RE: REVISED DRAINAGE PLAN FOR AN ADDITION @ 7000 ZUNI RD. S.E. (L18-D49)  
REVISION DATED 2/15/93.

RE: DRAINAGE PLAN FOR AN ADDITION @ 7000 ZUNI RD SE (L18-D49) ENGINEER'S  
STAMP DATED 2/15/93.

TITLE SITE, DRAINAGE, AND GRADING PLAN

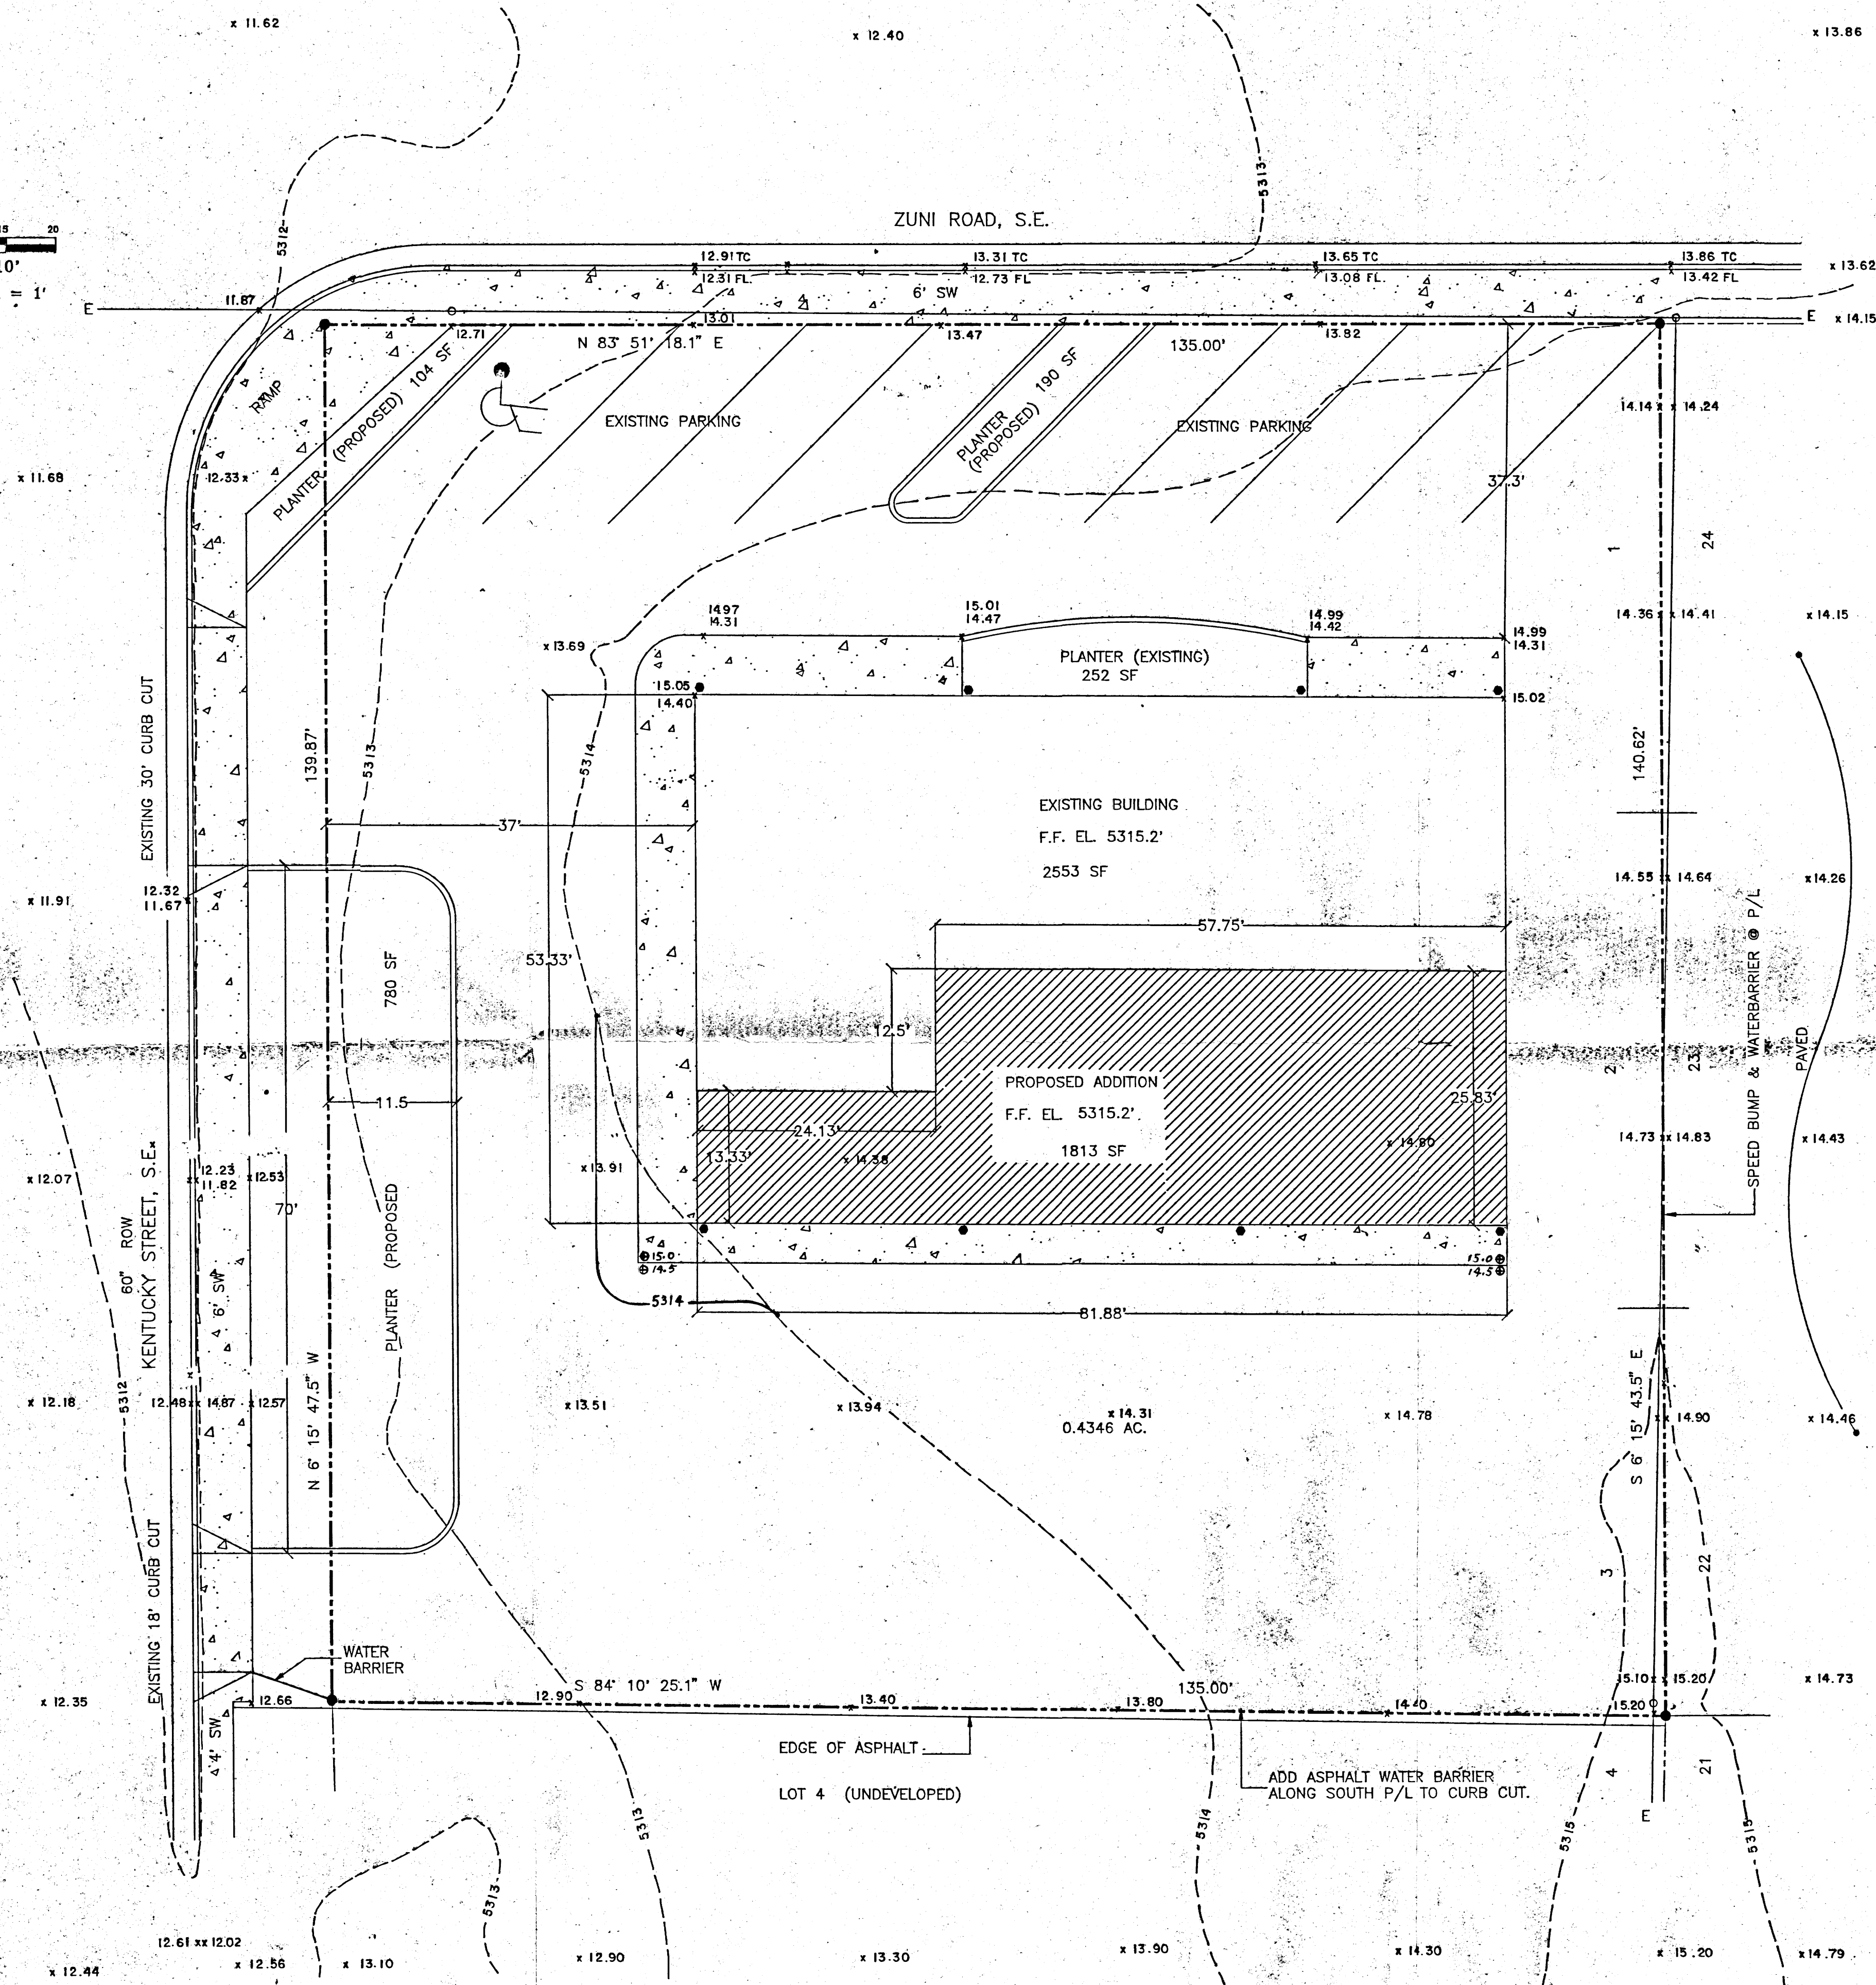
1. Identify direction and location of roof drains.
2. Asphalt curb will be required along the south boundary line to reroute the developed run-off toward the approved drive pad.

Based on the information provided on your March 1, 1993 resubmittal, the above referenced site is approved for Building Permit.
